From: Julie Grieves on behalf of Planning.Responses
Sent: 14 June 2019 08:35
To: Planning Scanning
Subject: FW: Objection A/55/19/PL
Attachments: Bungalows A5519PL.pdf

From: james mimpriss [REDACTED]
Sent: 13 June 2019 16:44
To: Anita Gardner
Subject: Objection A/55/19/PL

I object to A/55/19/PL for the same reason as A/31/19/PL with few additional material reasons.

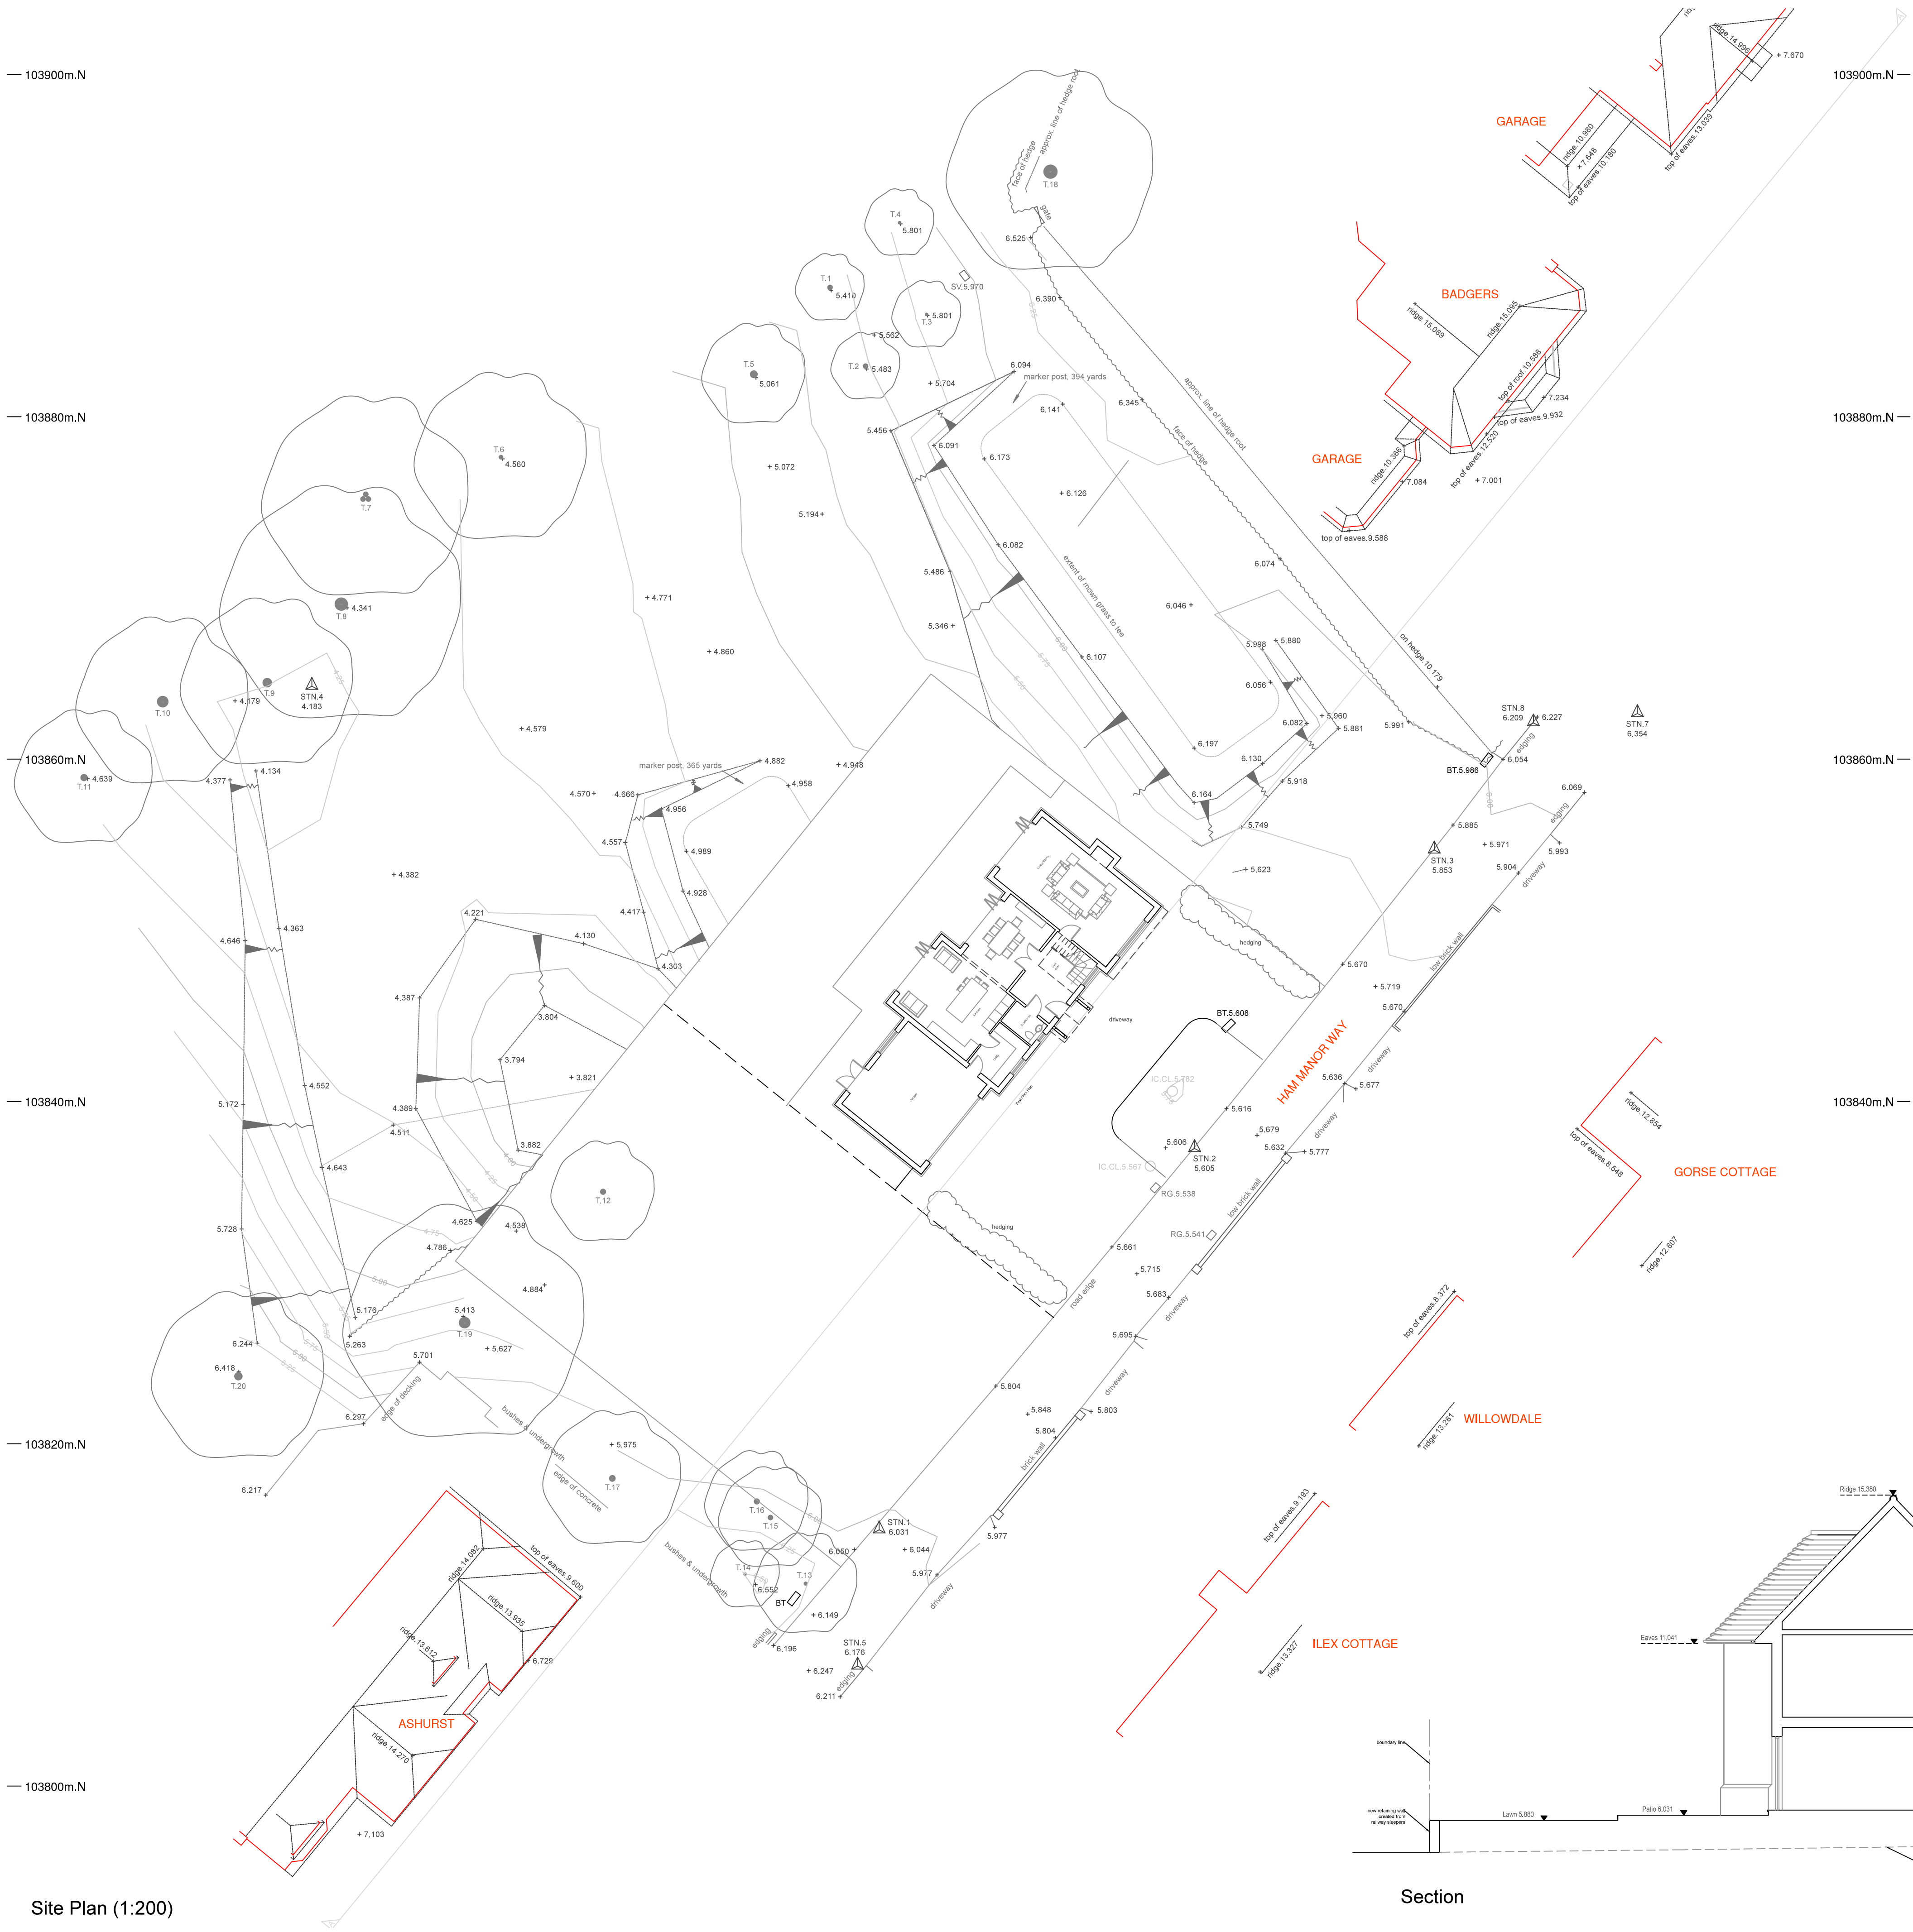
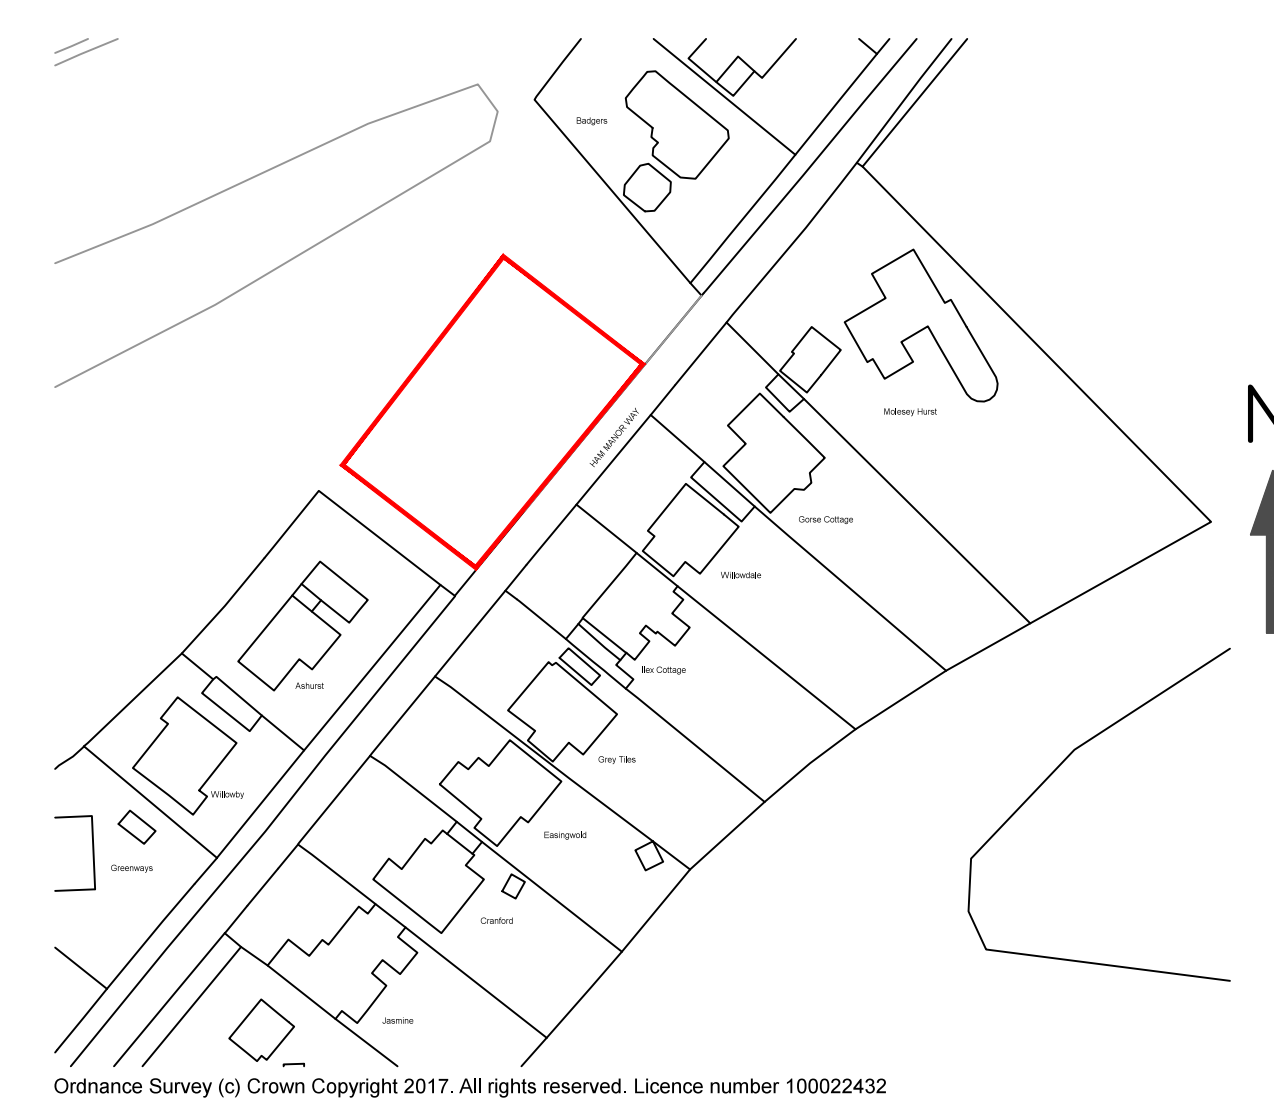
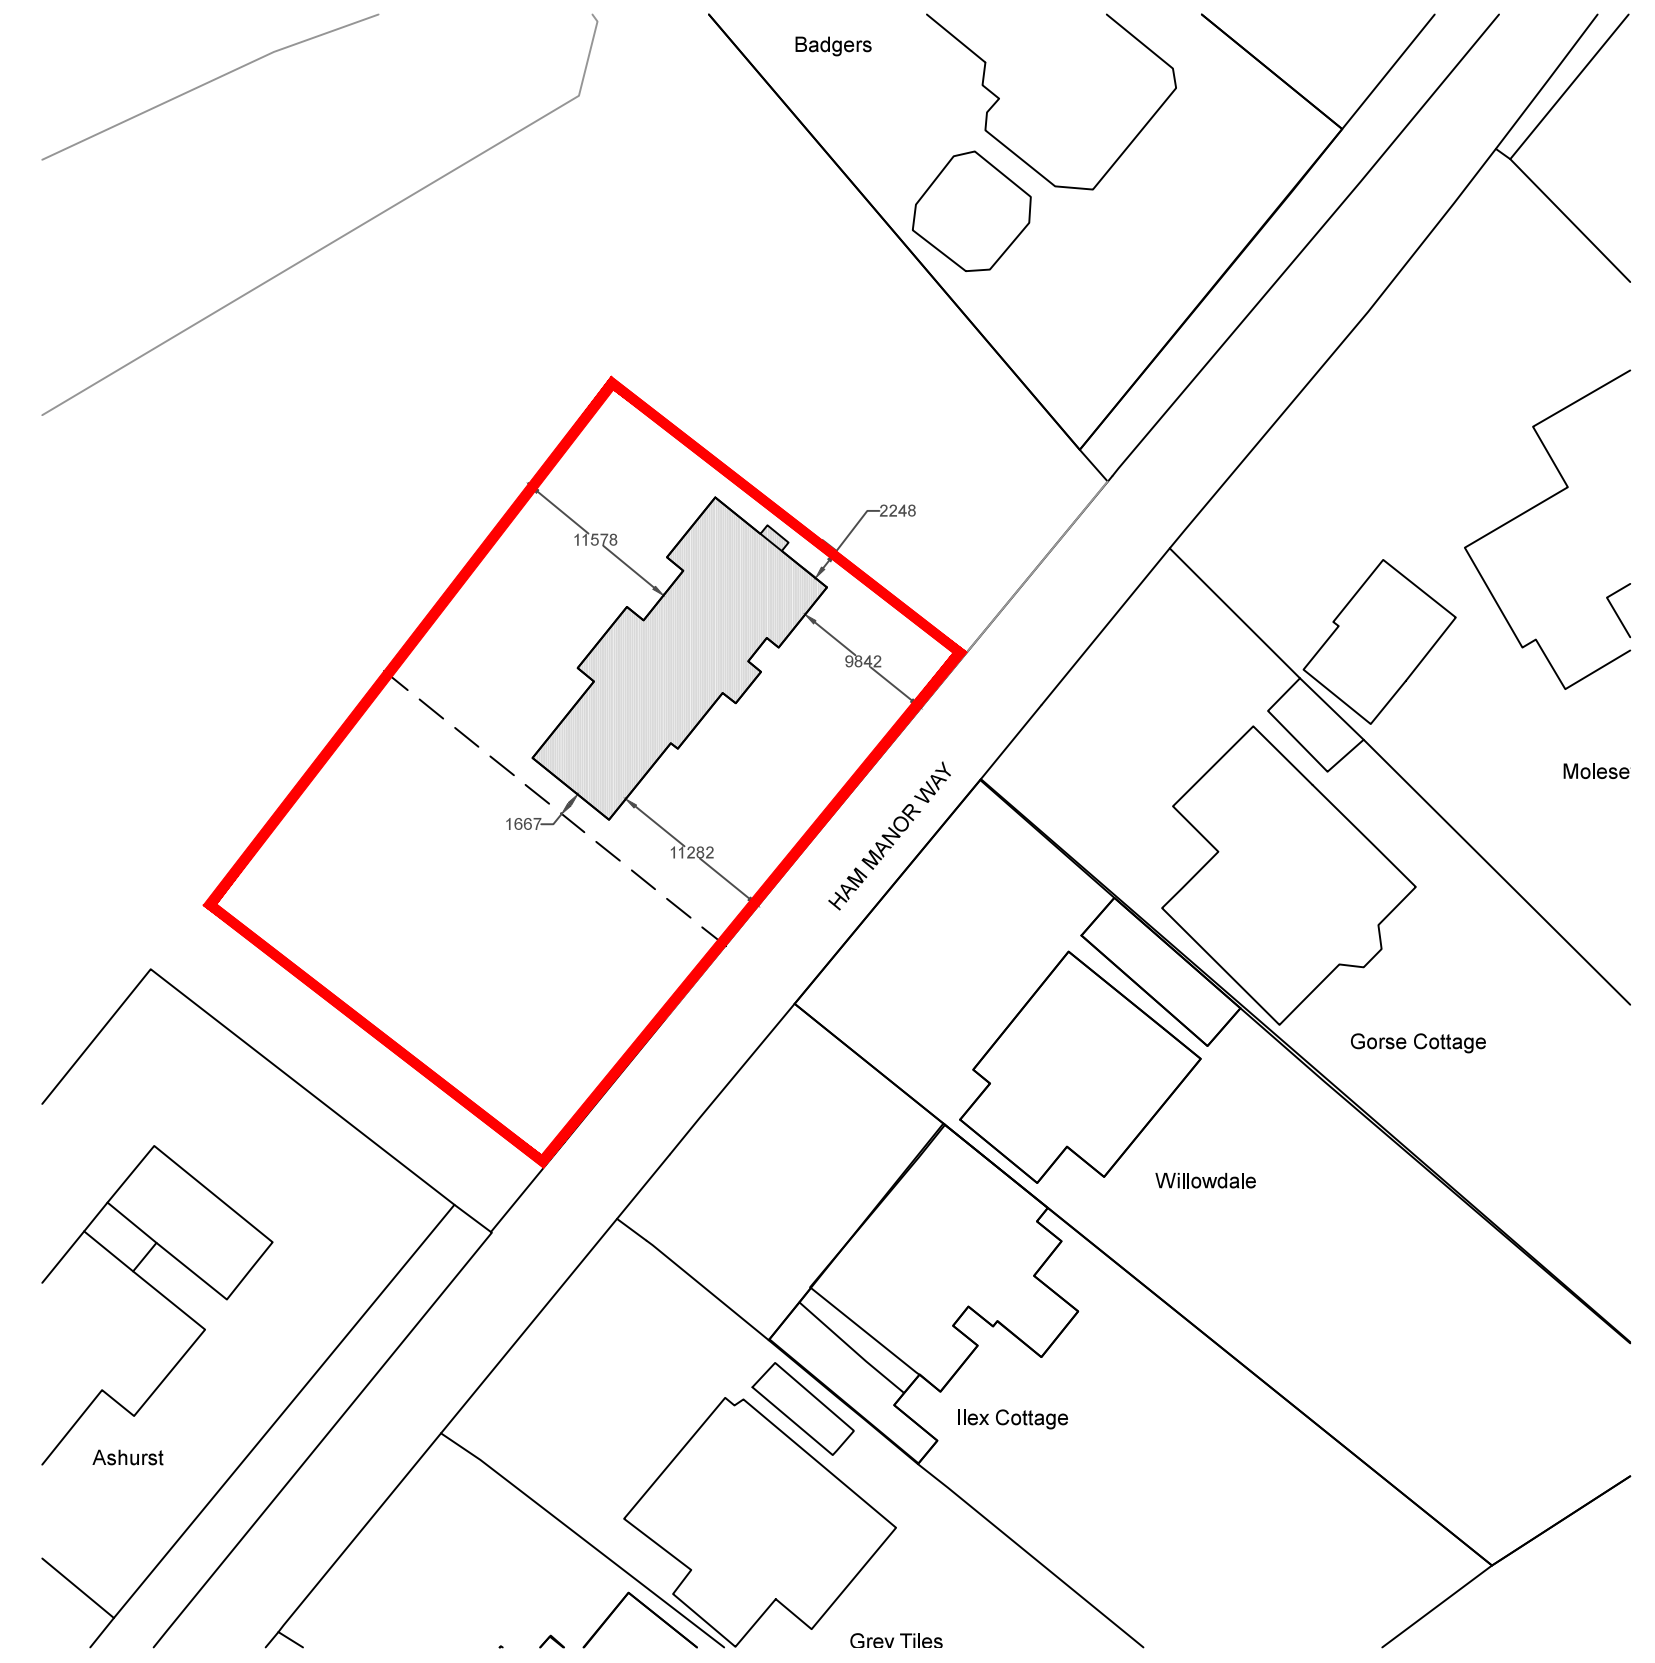
As shown on the submitted plan drawing, drawing number 1202.02.c, the proposed property is positioned a long way forward of the historical build line which can be seen from aerial photo's on Google map. On both sides of Ham Manor Way there is a defined line where properties are not built in front of. This again demonstrates the property is too big for the plot size whilst trying to gain a back garden.
